SUBJECT: BE/23/14/PL

**Change of use from Class B8 (Storage or Distribution) to Class A1 (Shops)
including partial demolition.**

**Adjacent warehouse site to McDonalds, Oldlands Way, Bersted, West Sussex,
PO22 9SA**

REF NO: BE/23/14/PL

West Elevation to Shripney Road

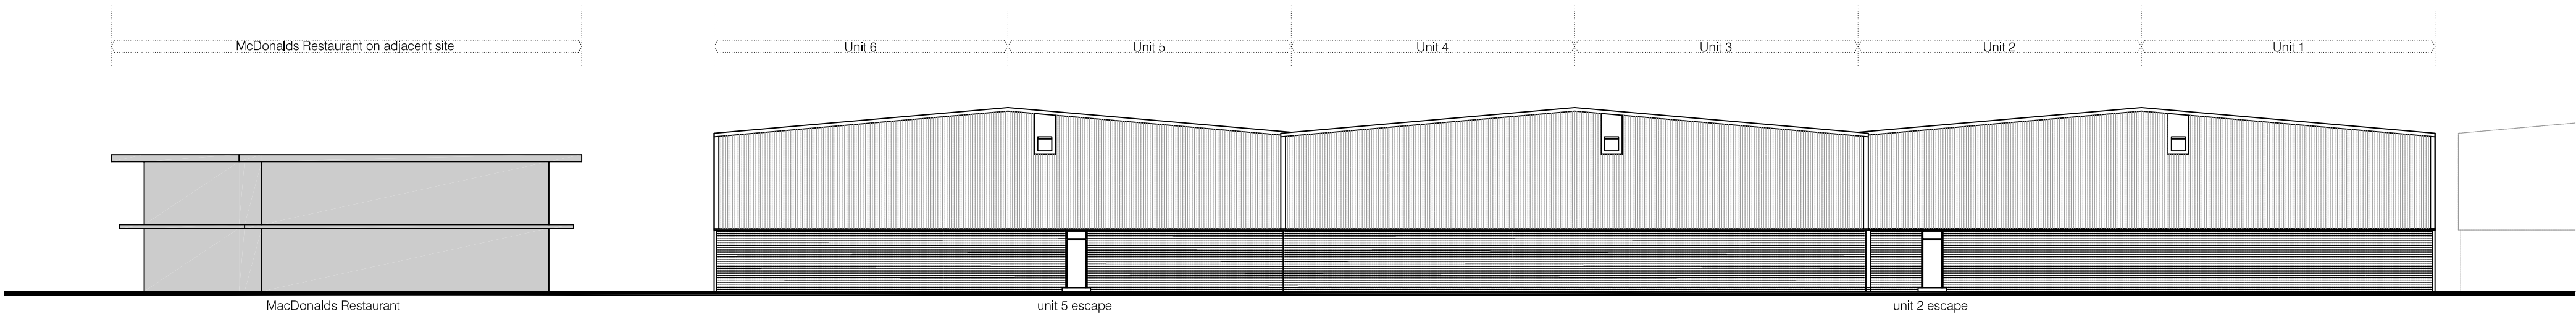
- 4 The introduction of hard landscaping and a green palisade fence to the Shripney Road frontage would be detrimental to the character & appearance of the local area. This would introduce an industrial feature into a streetscene which is currently characterised by grassed open space and a ranch style fence and this would be in conflict with policy GEN7 of the Arun District Local Plan.

However, members should also note that an amended site plan has been received which omits the proposed hardstanding and green palisade fence to the rear of the building. This amendment is reflected in the list of plans in condition 02 below.

(Architect's Layout Plan)

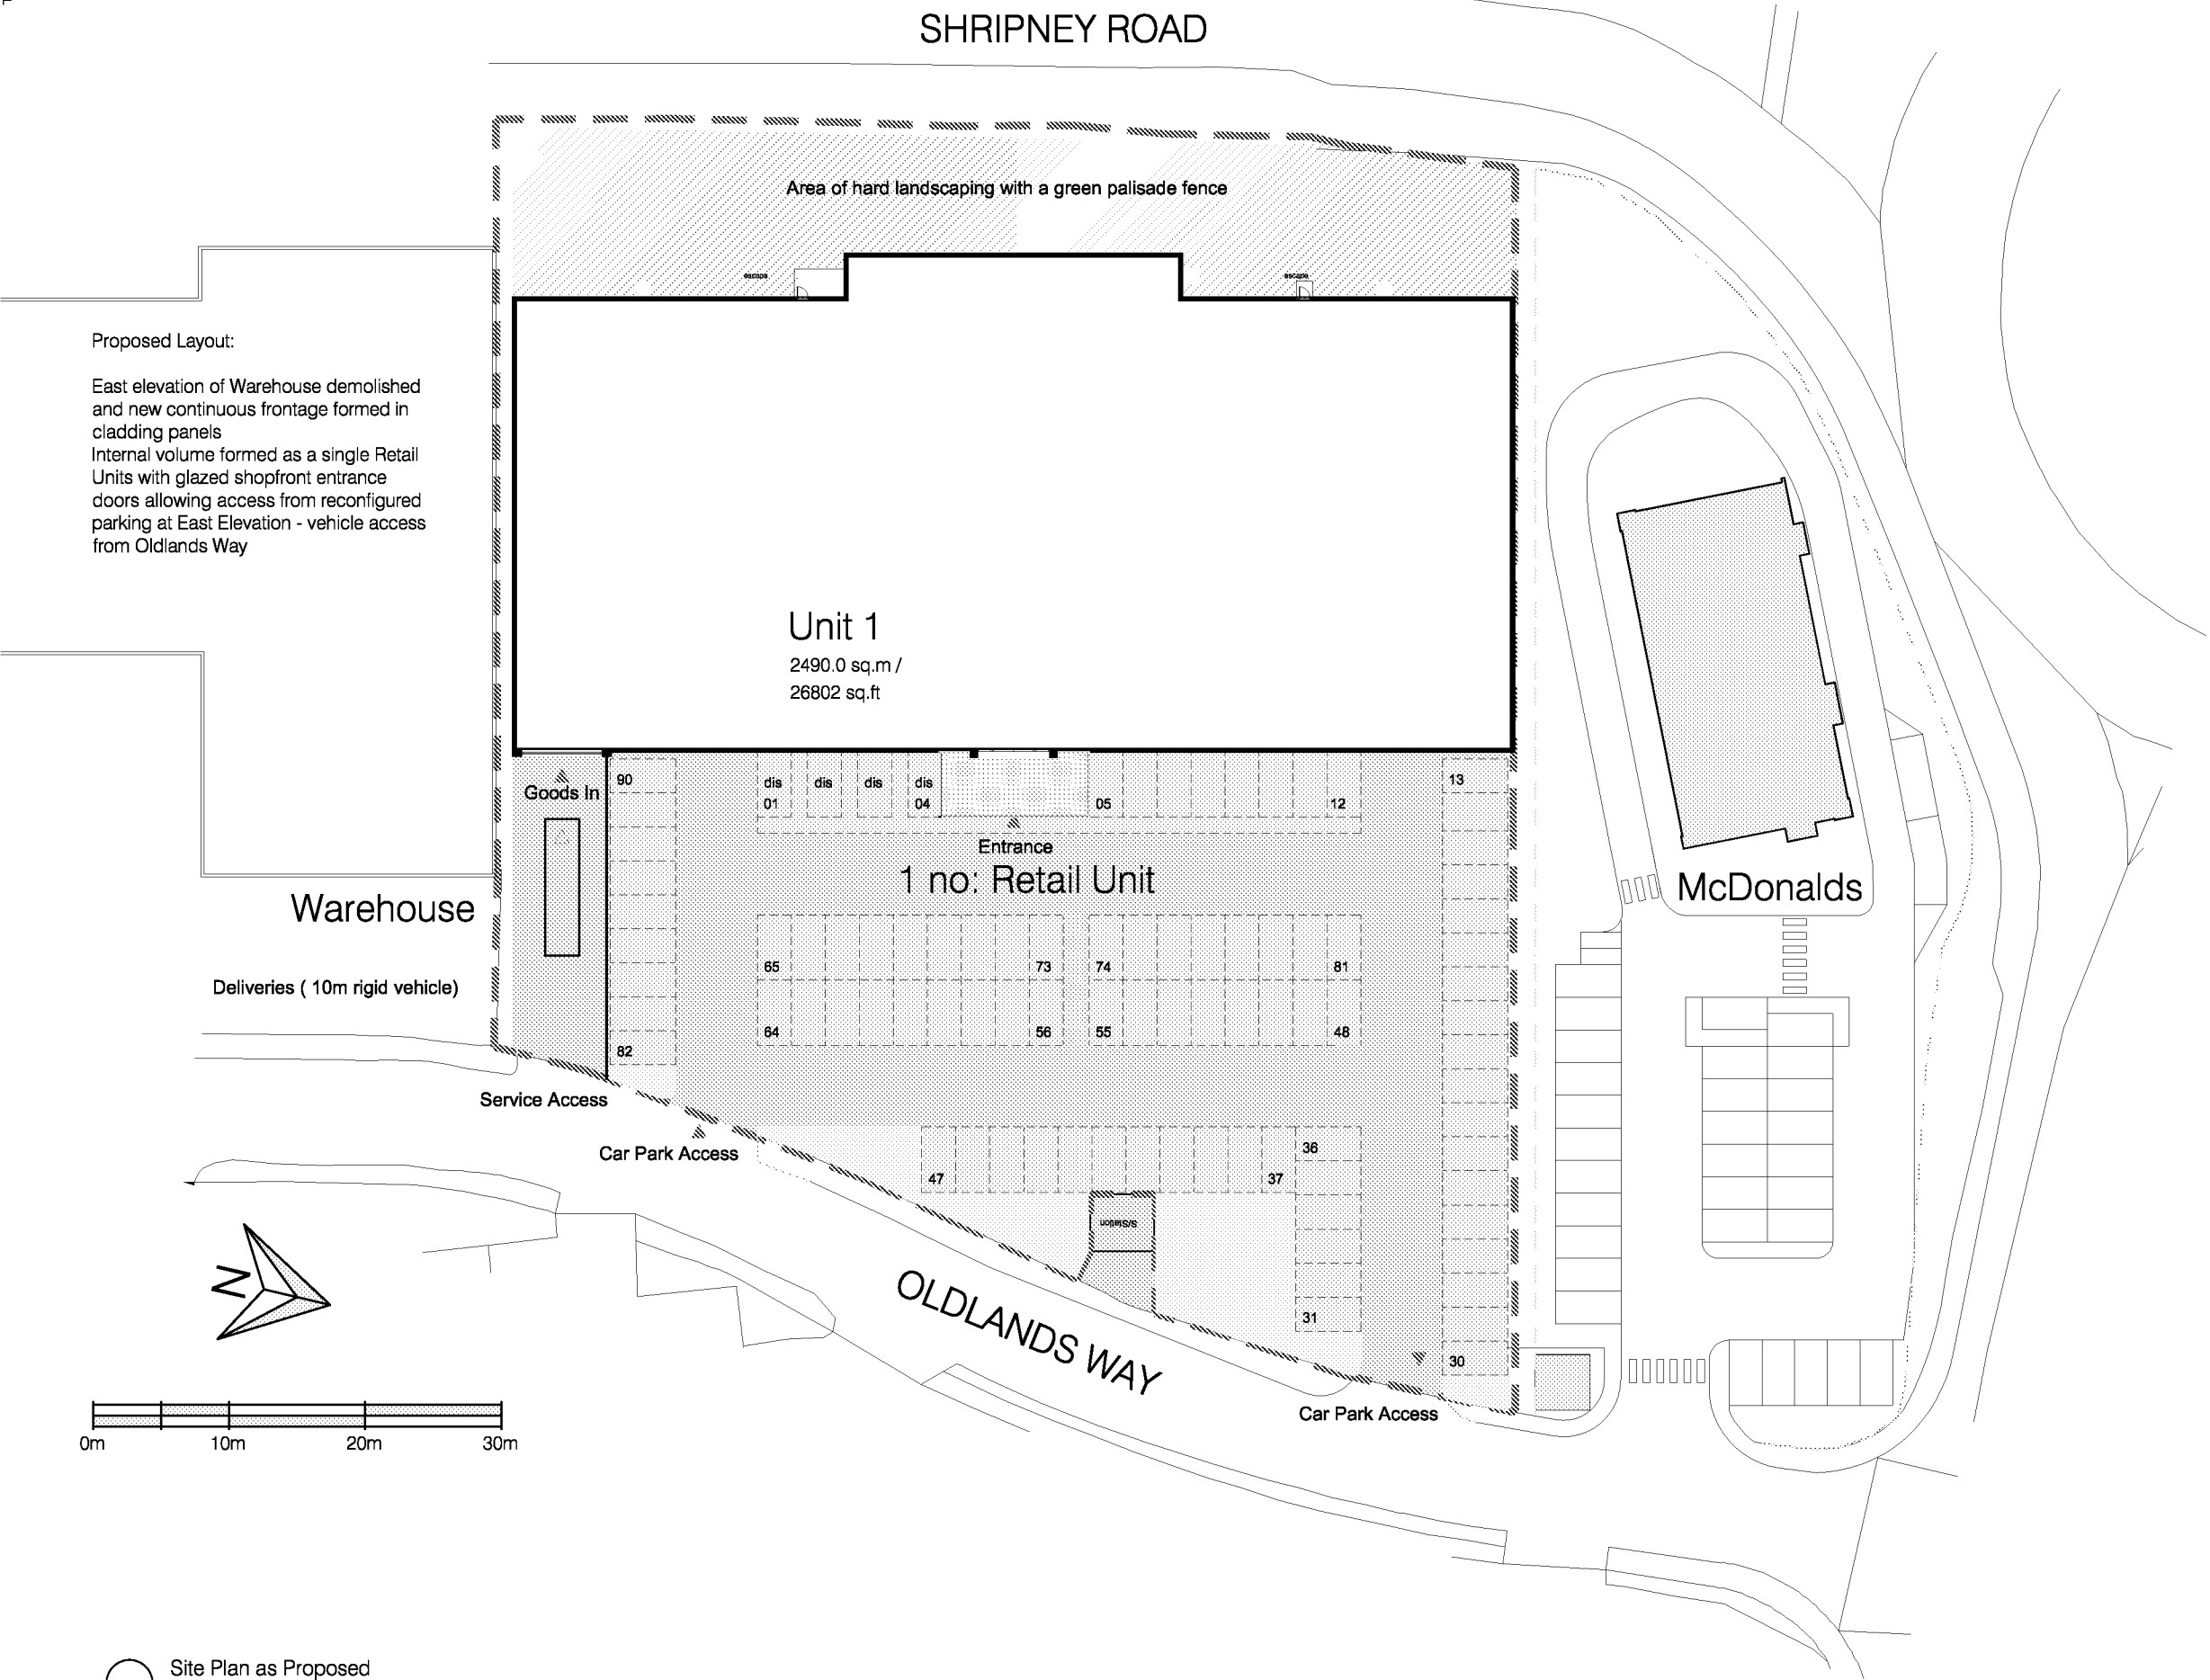
The proposals include revised access arrangements; while there appears to be a good level of visibility, splay should be provided on the access plans from a setback of 2.4m and in accordance with Manual for Streets guidance within either land owned by the Applicant or within the highway boundary.

The location of parking in the proximity of the access could result in the vehicles exiting the spaces coming into conflict with vehicles accessing the site, or result in Oldlands Way becoming obstructed unexpectedly while vehicles wait for the vehicles exiting the space.

The plans do not appear to indicate a route for pedestrians from Oldlands Way, who would instead be expected to share the internal car park roads. Provision should be made to provide a dedicated provision to encourage the use of sustainable modes. In addition, there appears to be no provision to encourage cycle journeys such as sheltered and secure parking.

Firstly, with regard to the WSCC Highways objection, the applicant has submitted a Draft Travel Plan and also an amended site plan, the latter which identifies pedestrian routes, cycle parking spaces, staff parking spaces and disabled parking spaces. The applicant has also confirmed to WSCC Highways that food retail is not part of the proposal. As a result, WSCC Highways have stated that parts (a) and (c) of the refusal reason no longer apply. However, WSCC Highways still require the submission of a Stage 1 Road Safety Audit and Designer Response. They have stated that this cannot be made the subject of a planning condition. Therefore part (b) of the refusal reason must remain.
